## Appendix A – Response to Agency Submissions (SSD 9670) Western Sydney University Innovation Hub – 2-6 Hassall Street, Parramatta

The following table includes a response to the full text of submissions provided by or on behalf of State and local government agencies. For completeness, the full text of each submission is provided in the left-hand column, accompanied by the proponent's corresponding response in the right-hand column. The proponent's responses have been informed by input by the expert consultant team and should be read in conjunction with the publicly exhibited Environmental Impact Statement and accompanying technical reports, as well as the Response to Submissions Cover Letter to which this document is appended.

Project No.
18032
Drawing No.
10.07
Revision
K

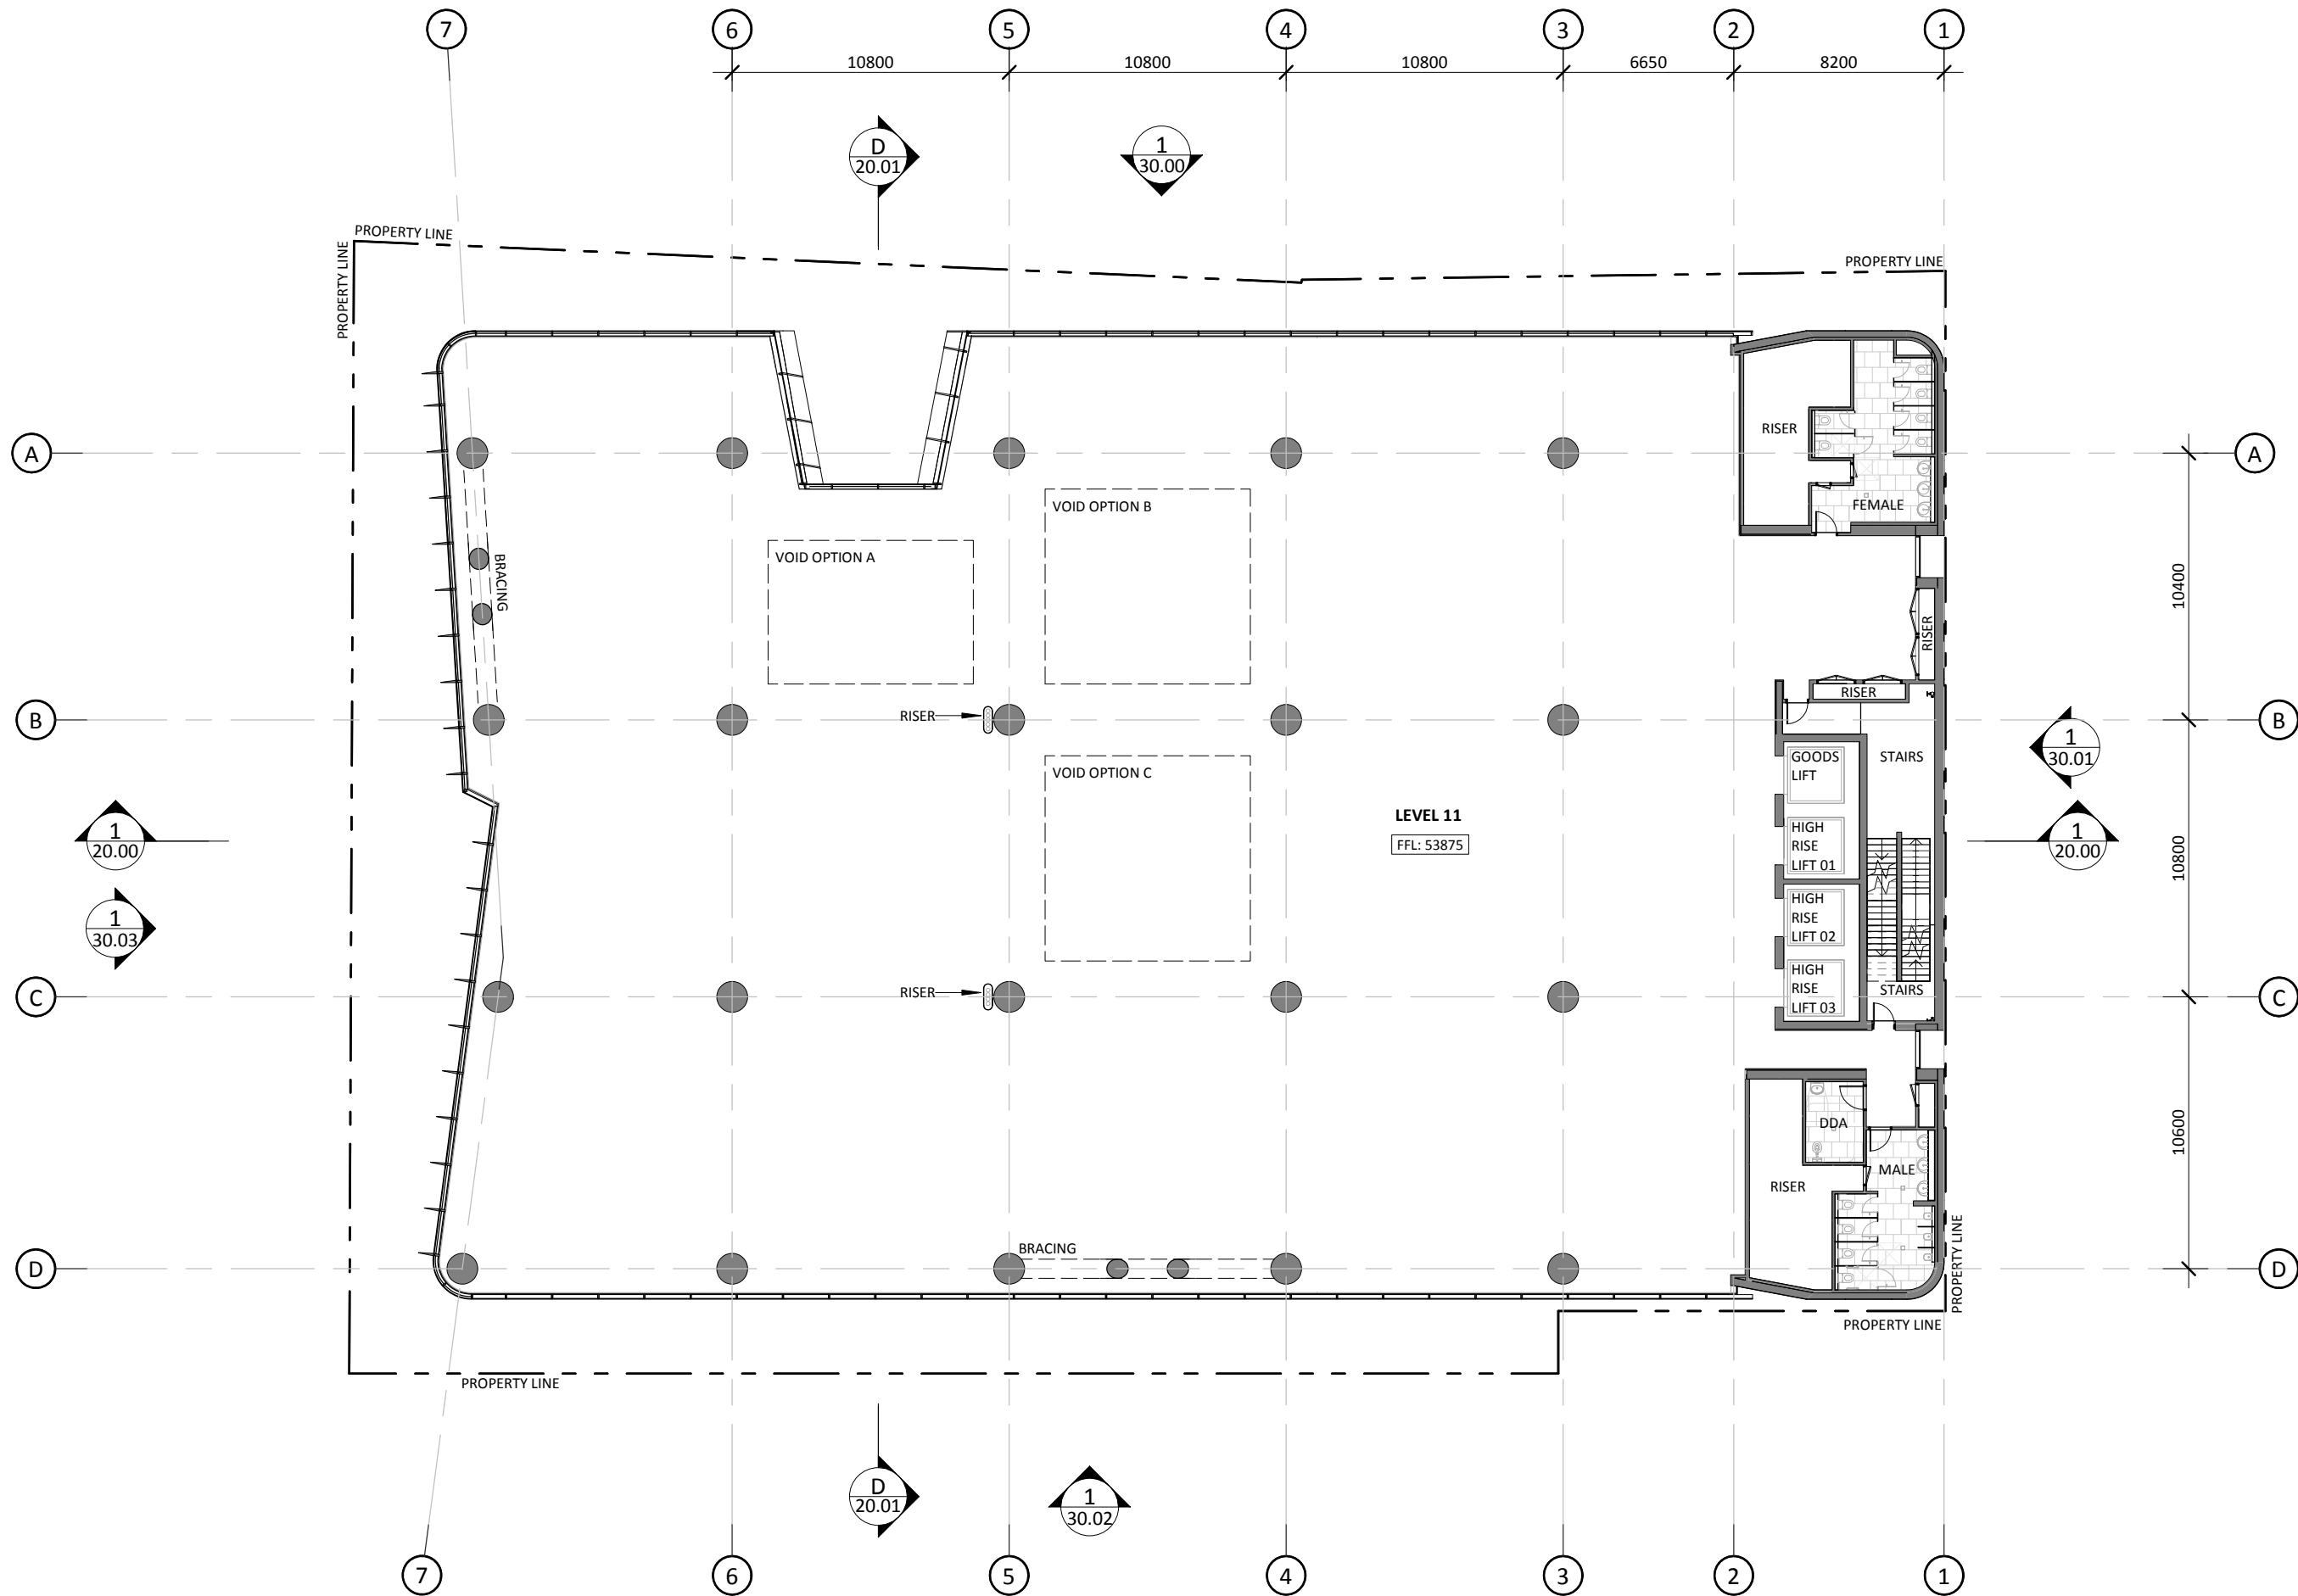
Item Raised		Proponent's Response
CoP 3e	<ul style="list-style-type: none"> <li>To reduce the risk of a person with vision impairment colliding with the columns, ensure provision of a minimum luminous contrast of 30% to the paving.</li> </ul>	Material schedule added to clarify required luminous contrast between column and paving. See Architectural drawing 10.01.
CoP 4a	<p><b>Universal Access Requirements Terrace (level 10 &amp; 12):</b></p> <ul style="list-style-type: none"> <li>All doorways from the level 10 and 12 areas leading to the terrace must provide low level thresholds with a construction tolerance of no more than 3mm.</li> </ul>	See Architectural drawing 52.05, Detail 1 typical terrace door sill showing flush threshold.
CoP 4b	<ul style="list-style-type: none"> <li>Ensure the doors from both floors leading to terraces provide a clear opening of 850mm including the active leaf of any set of double doors. This should also apply to the doors providing access to amenities.</li> </ul>	Dimension added to doors to terrace. See Architectural Drawings 10.07 and 10.09
